Memorandum

To: Carmen Moran
CC: Nancy Cline
From: Clay Barnett
Date: 1/11/2008
Re: Thomas Development Addition

PRELIMINARY PLAT
THOMAS DEVELOPMENTS ADDITION
94,098.93 SQ.FT. / 2.1602 ACRES
WILLIAM LOMAX SURVEY, ABSTRACT NO. 792
TOWN OF ADDISON, DALLAS COUNTY, TEXAS

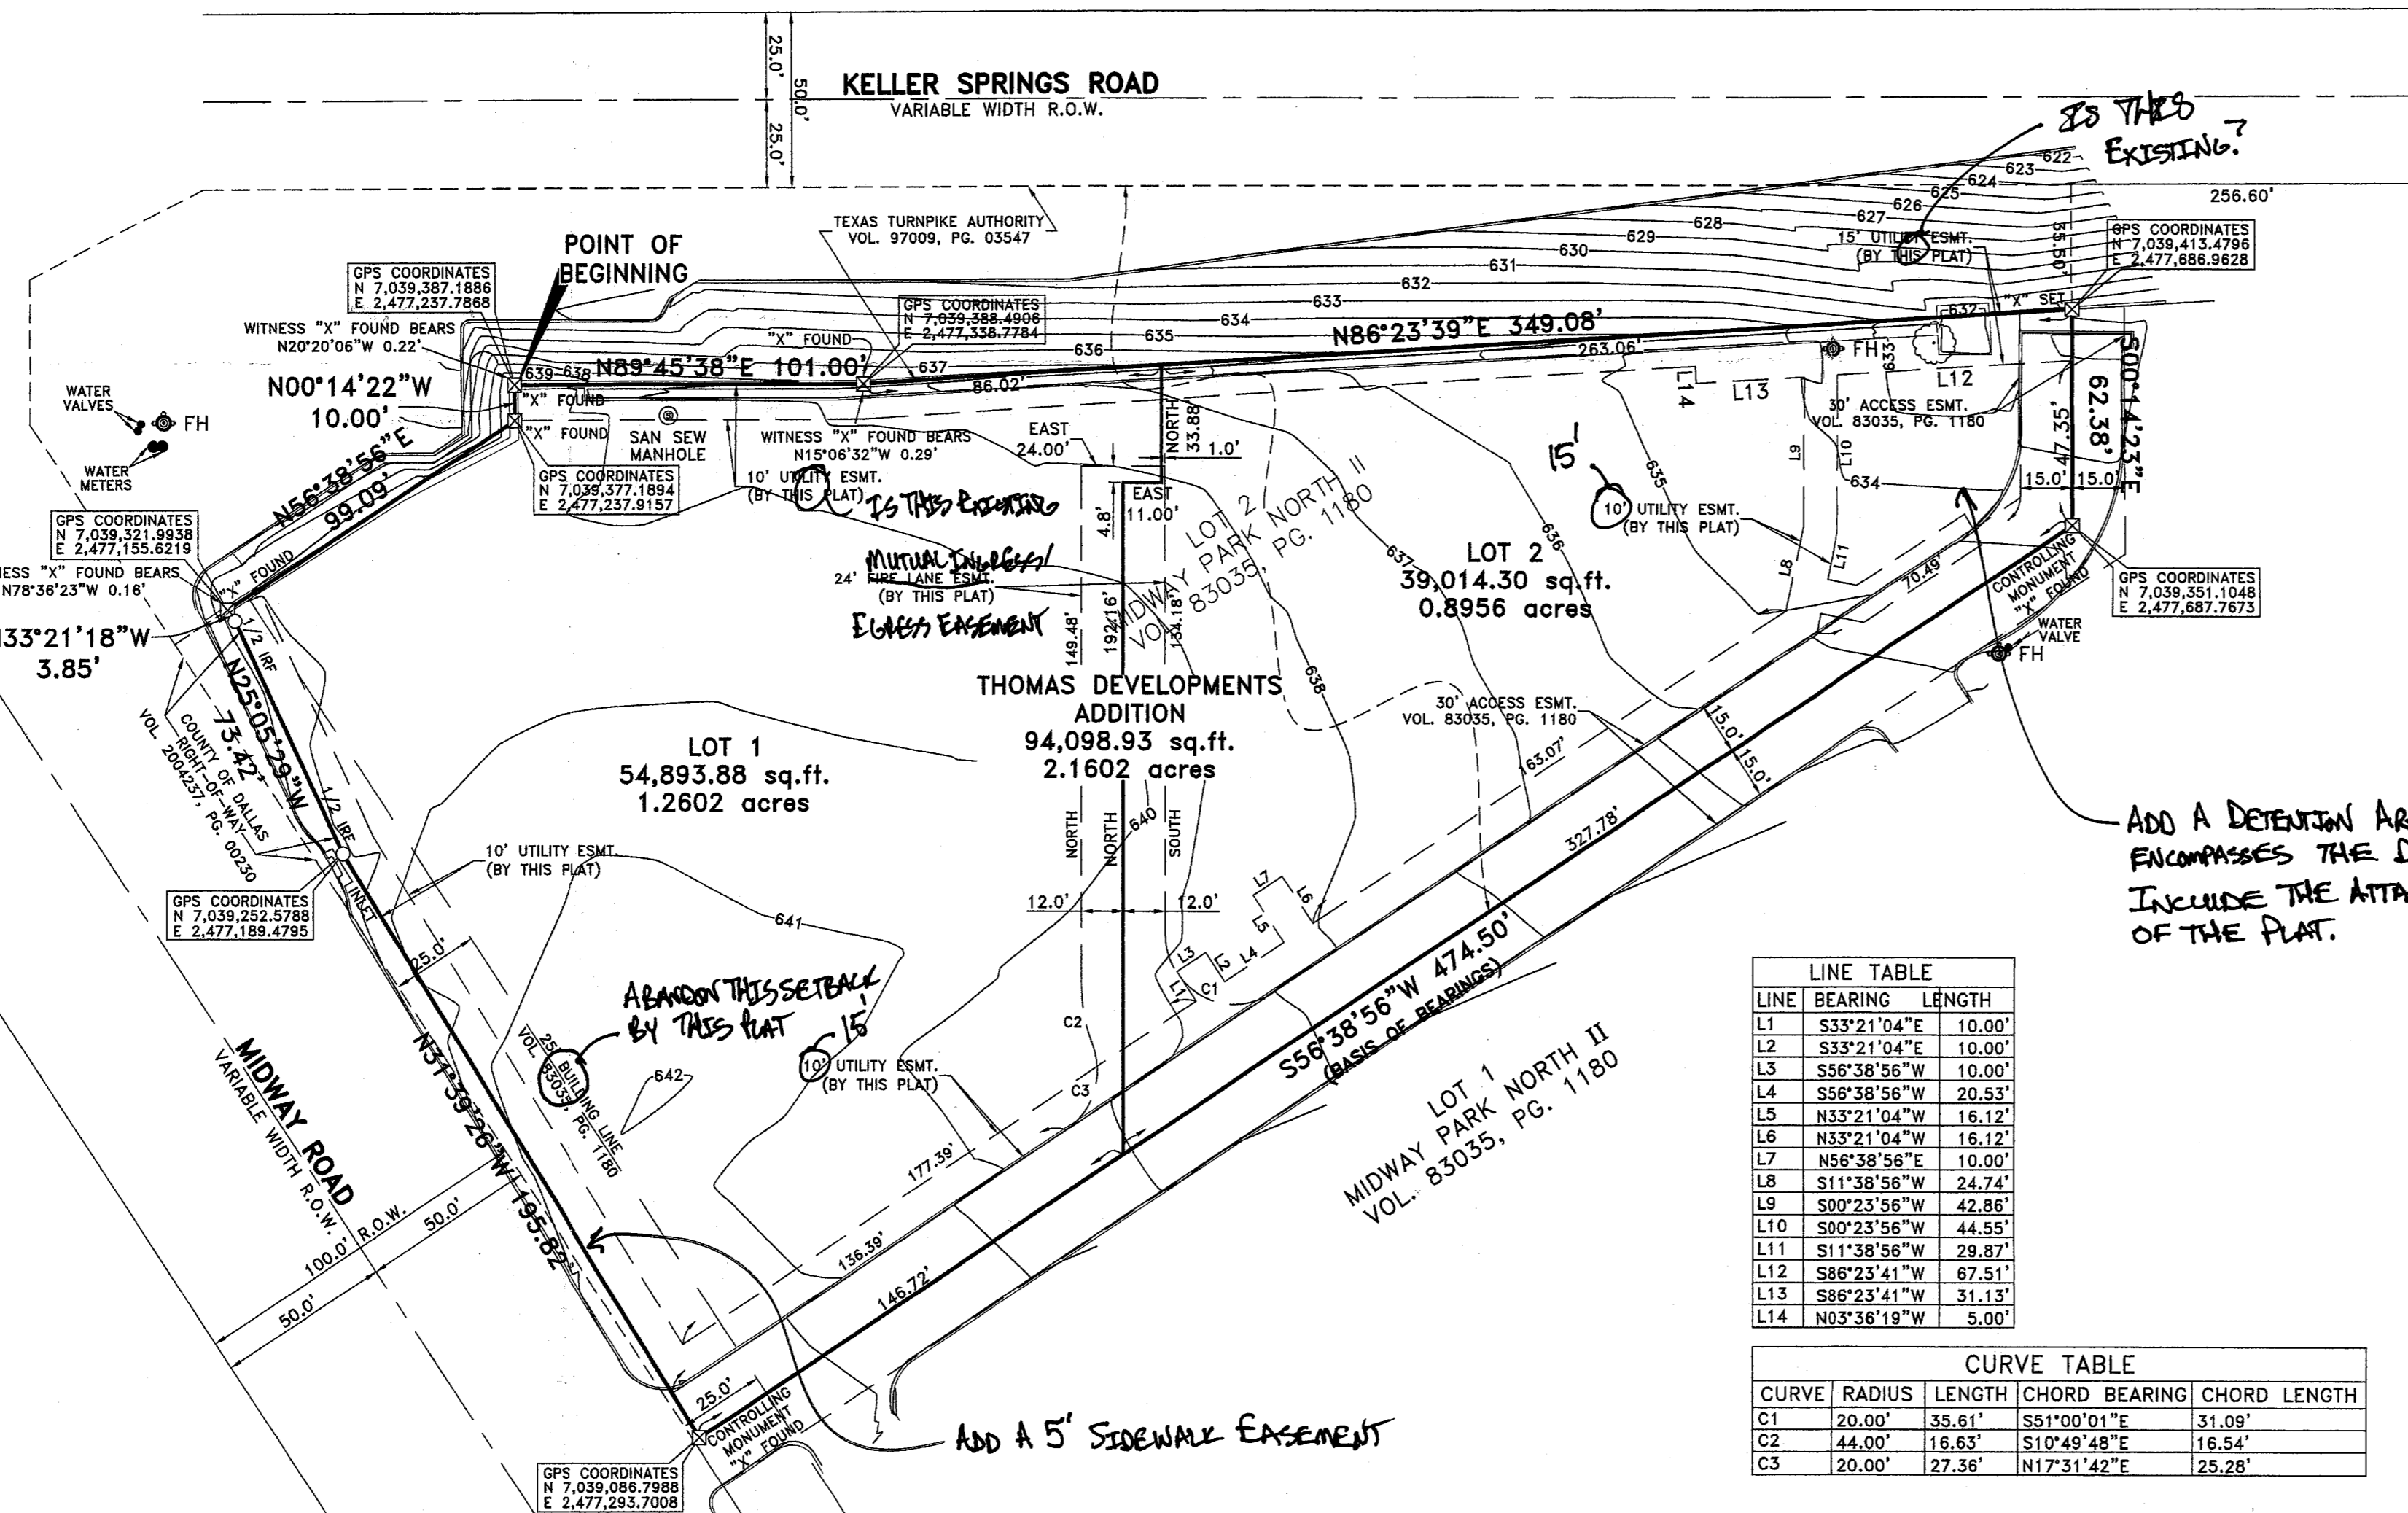
-
1. Add a 5' Sidewalk Easement along Midway Road.
 2. Abandon the 25' Building Setback along Midway Road by this plat.
 3. Change the 10' Utility Easements for all water mains to 15' Water Easements.
 4. Change the 24' Fire Lane Easement to a 24' Mutual Ingress/Egress Easement.
 5. Remove the last five paragraphs from the Owner's Dedication.
 6. Add a Detention Area Easement that encompasses the detention pond and add the attached Detention Area Easement language to the face of the plat.
 7. The Utility Easement along the Addison Toll Tunnel is called out to be proposed. However, our records indicate that it exists. Please verify.
 8. Provide a closure sheet.
